associated
earth sciences
incorporated

February 29, 2024
Project No. 20220141E001

Subject: Response to City Comments
Chase (Fused Elements) Residence
4525 Forest Avenue SE
Mercer Island, Washington

Geotechnical Report: Subsurface Exploration, Geologic Hazard, and
Geotechnical Engineering Report
Chase Residence
Mercer Island, Washington
Dated August 16, 2022

DESIGN SECTION 17' Tall Wall With Tiebacks

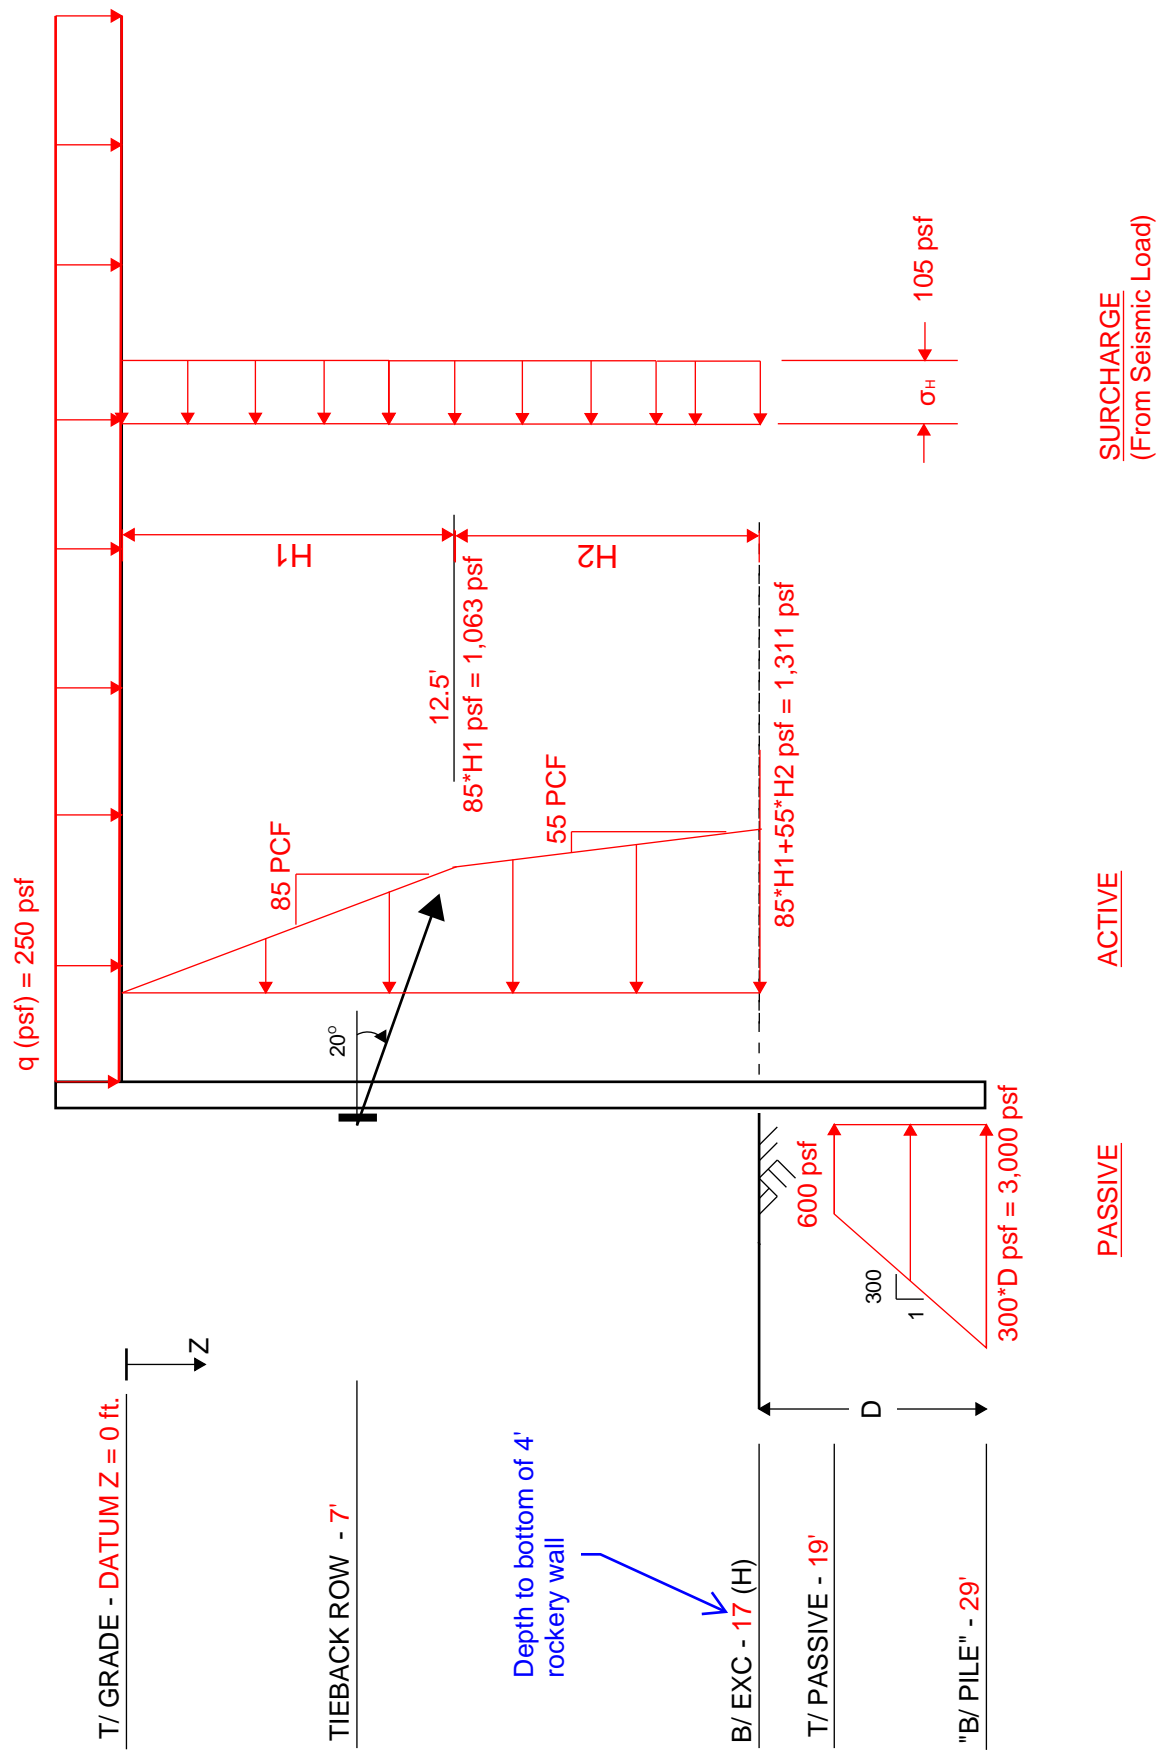
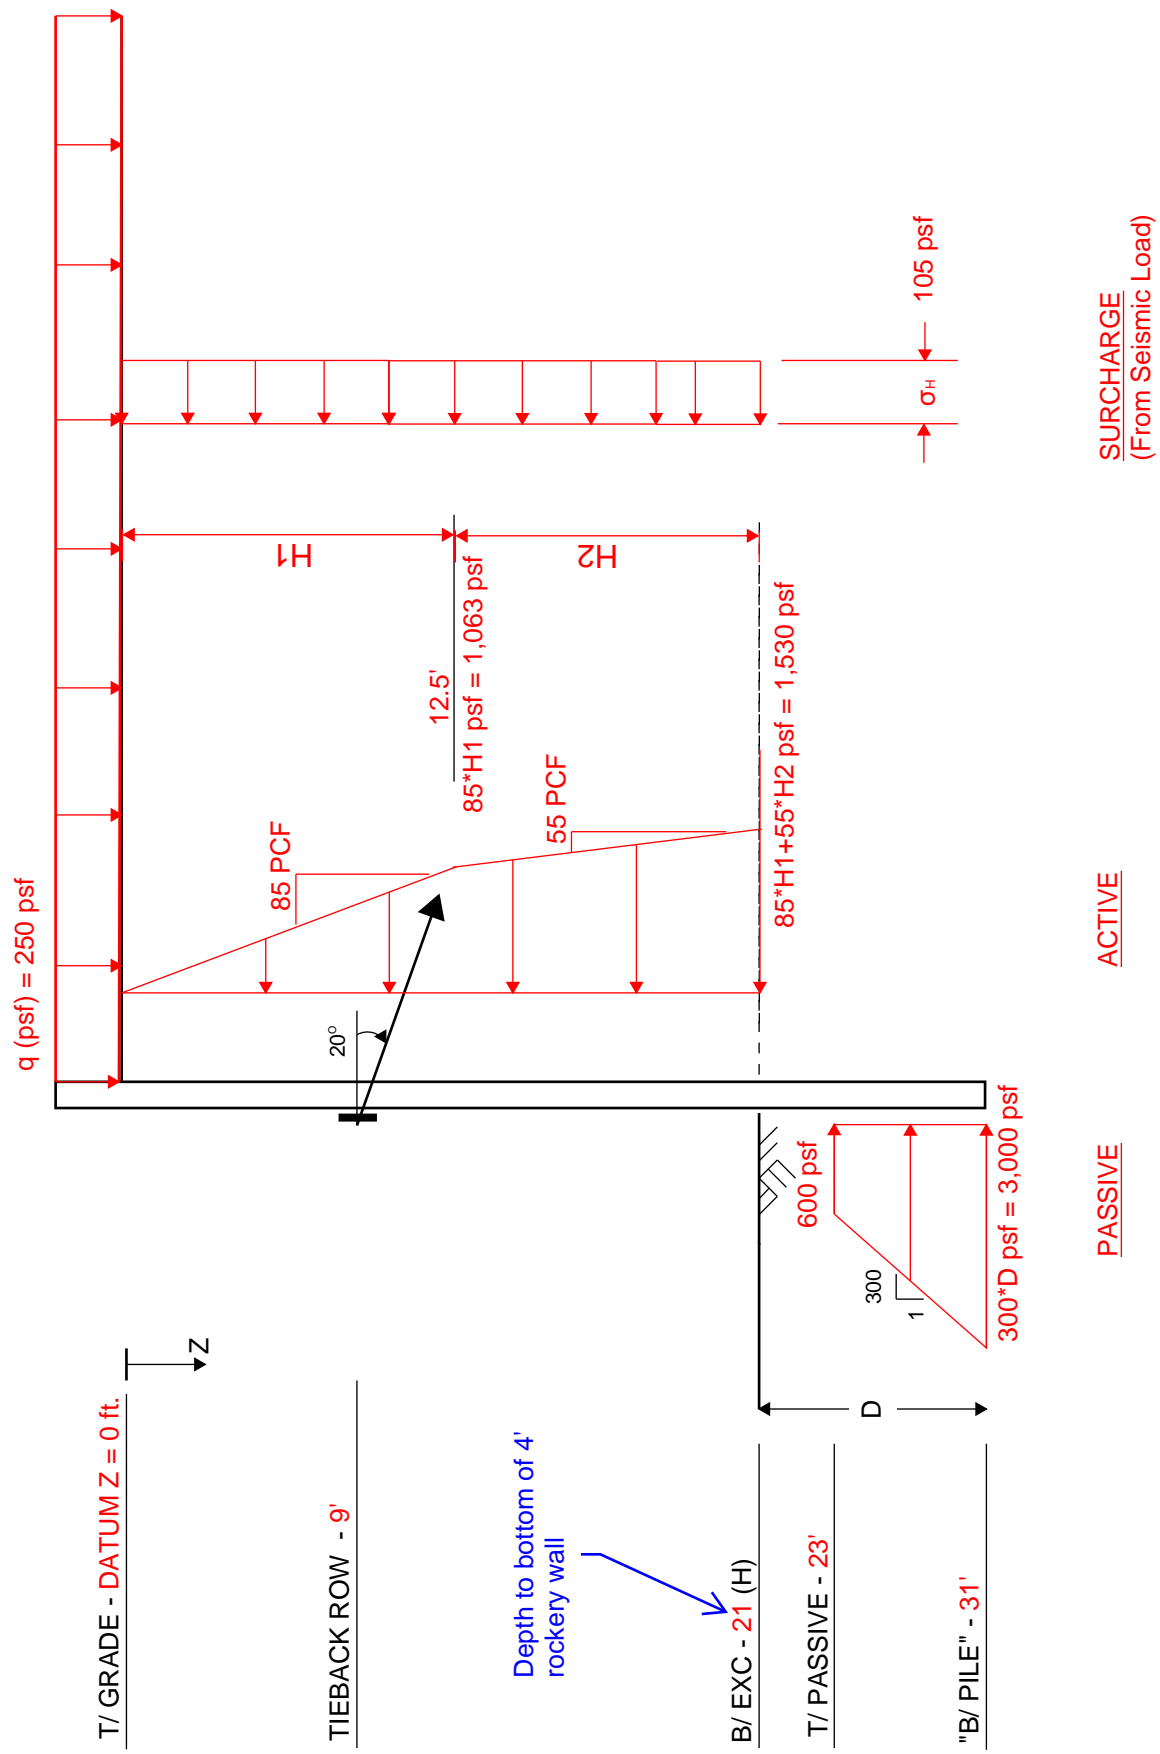
Please revise design lateral soil pressures to reflect current design.

The pressure diagram presented in our August 16, 2022 report provides for various surcharges. We understand that the previously-submitted structural plans included a different pressure diagram than that presented in our August 16, 2022 report, and that the current plans now reflect our recommendations.
